# KITTITAS COUNTY

### MEMORANDUM

**TO:** All Staff  
**FROM:** Public Works Plan Review Team  
**DATE:** August 26, 2022/Revised October 10, 2022  
**SUBJECT:** BL-22-00017 Rosenberry

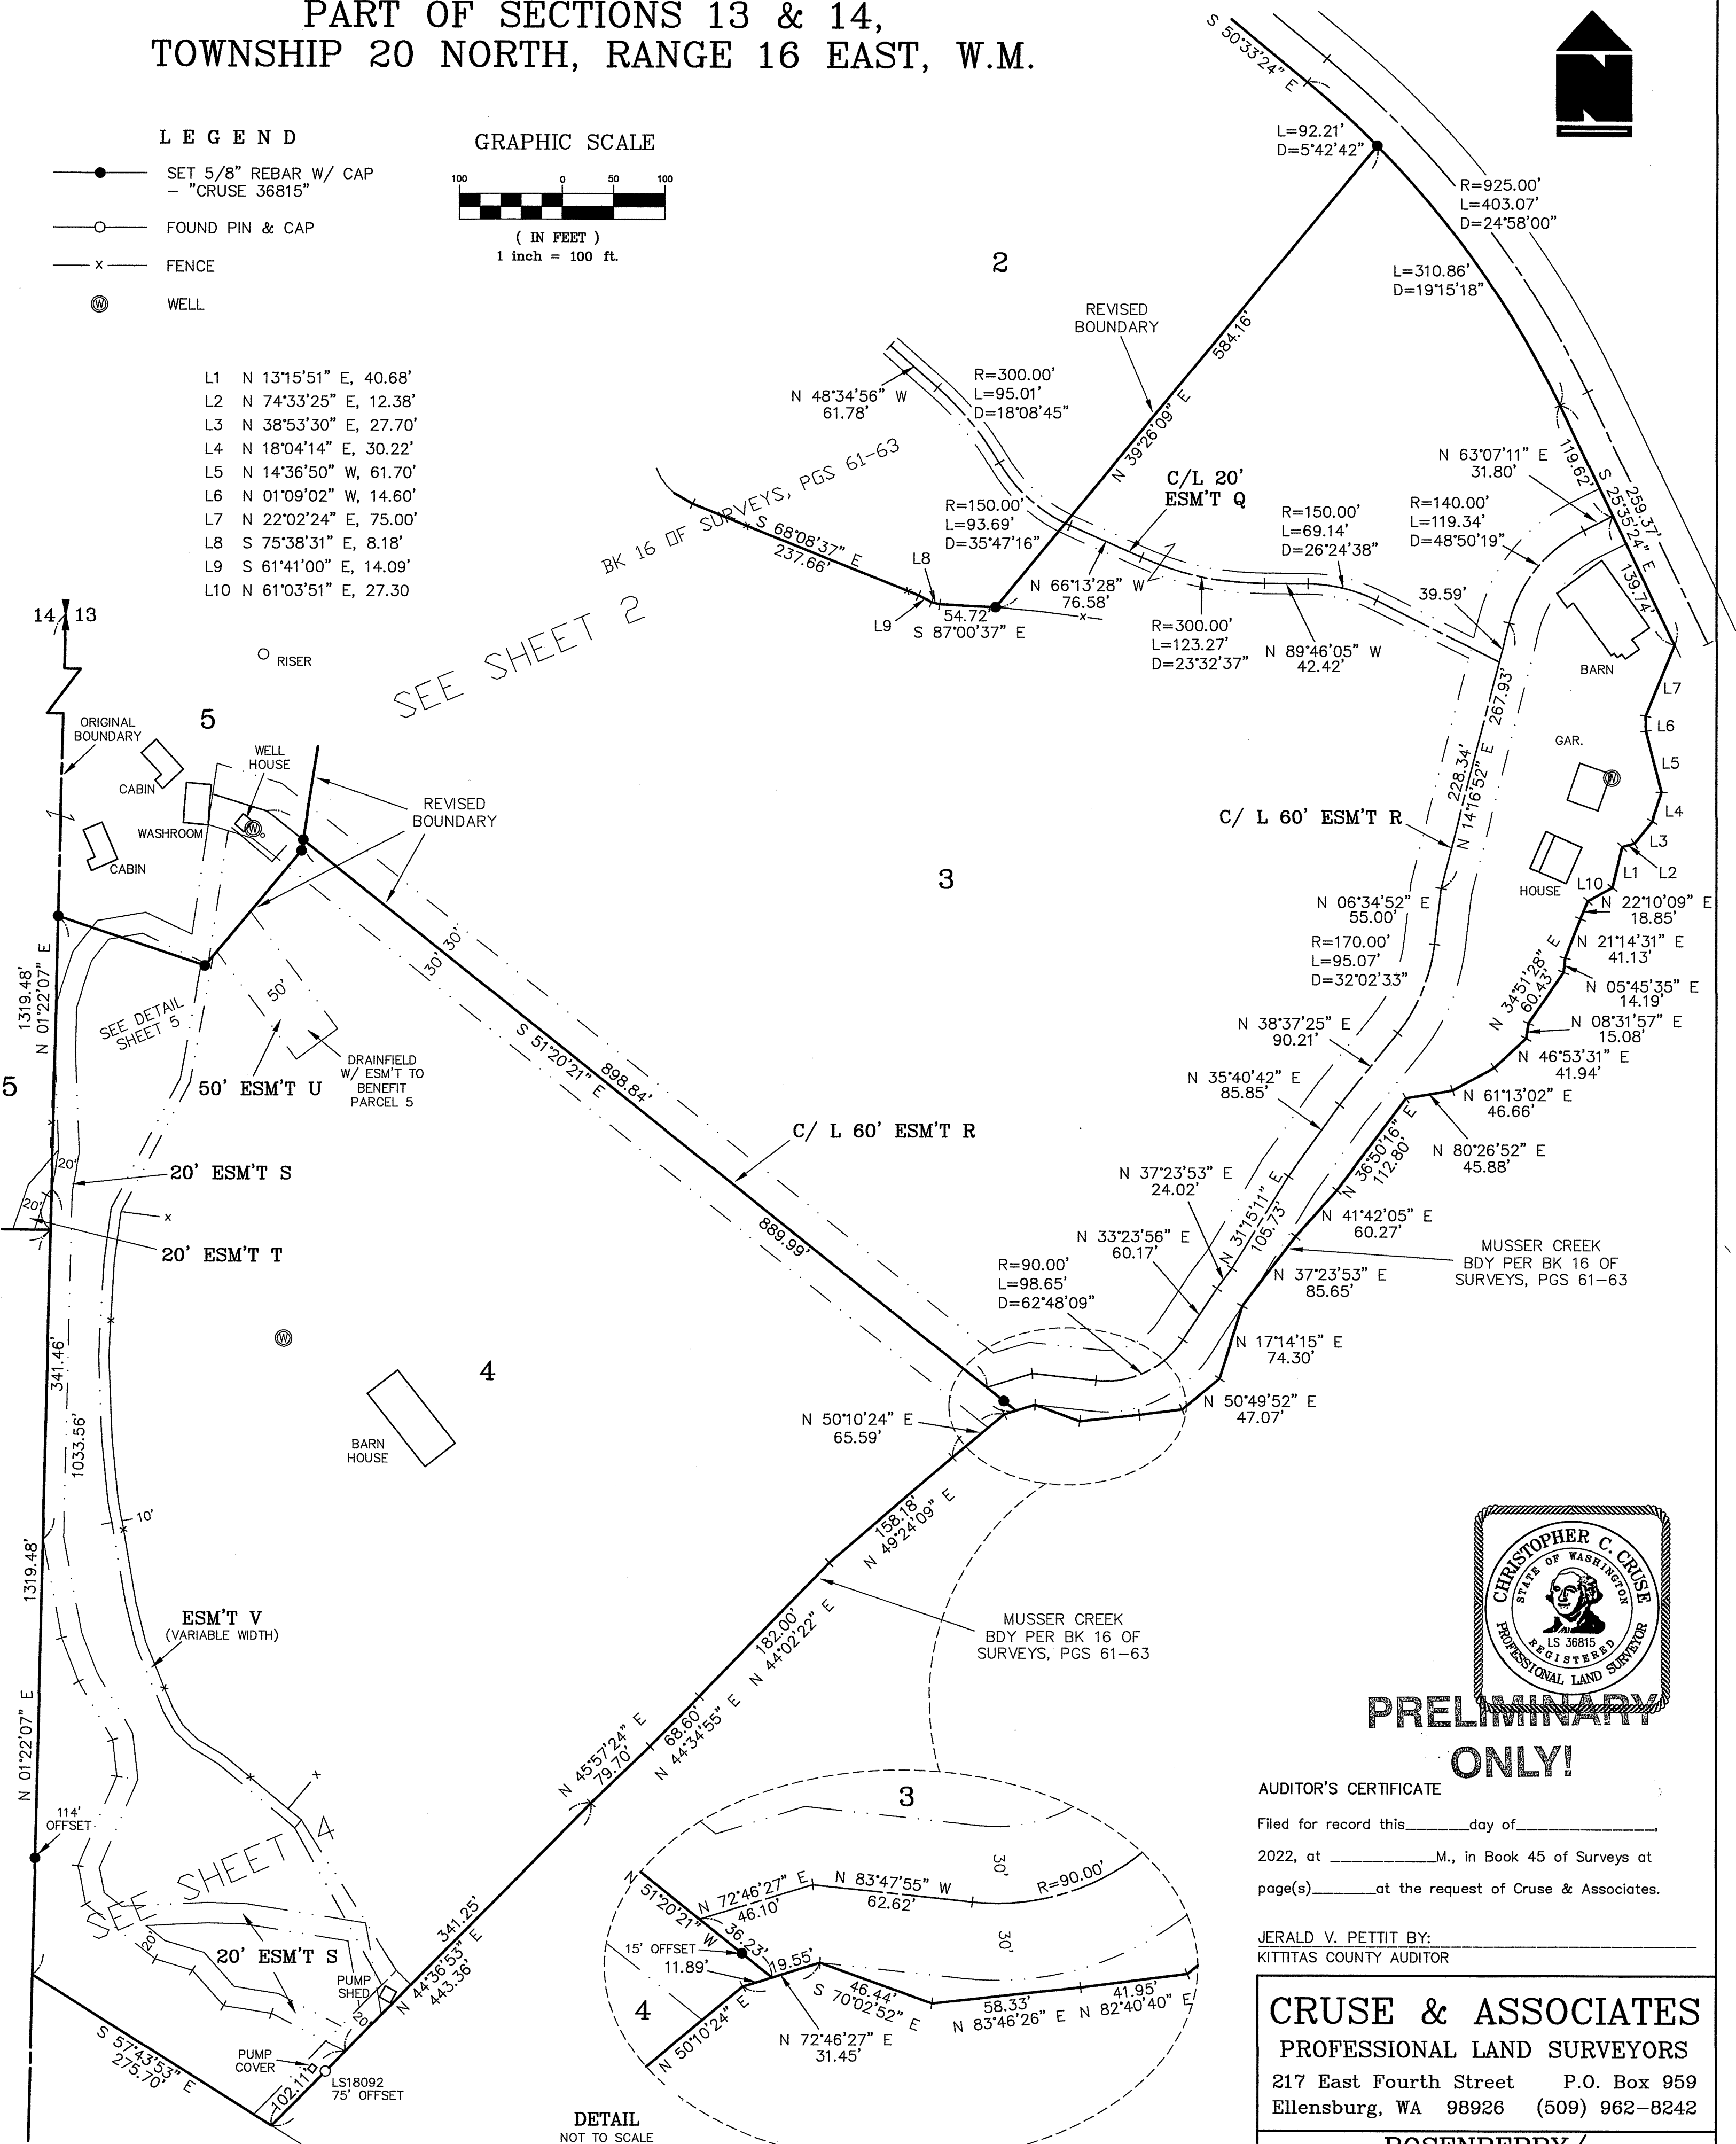
<p>description.</p> <p>2. Please label the line table on Sheet 3.</p>
<b>FLOOD</b>	<p>Portions of proposed parcels 1 and 4 will be located in the 100-year floodplain and floodway. If possible, any future development should remain outside of the floodplain in order to reduce risk and avoid mandatory flood insurance purchase requirements. The floodway is highly restricted, and any development must demonstrate no rise in the level of the 100-year flood before being permitted. No new or substantially improved residences are allowed within the floodway. All activities within the floodplain must be permitted through the floodplain development permit process and follow the regulations within KCC 14.08.</p> <p>While not required by KCC 14.08.220, it is suggested that the floodplain and floodway boundaries are outlined on the face of the recorded survey.</p>
<b>WATER MITIGATION/ METERING</b>	No comments
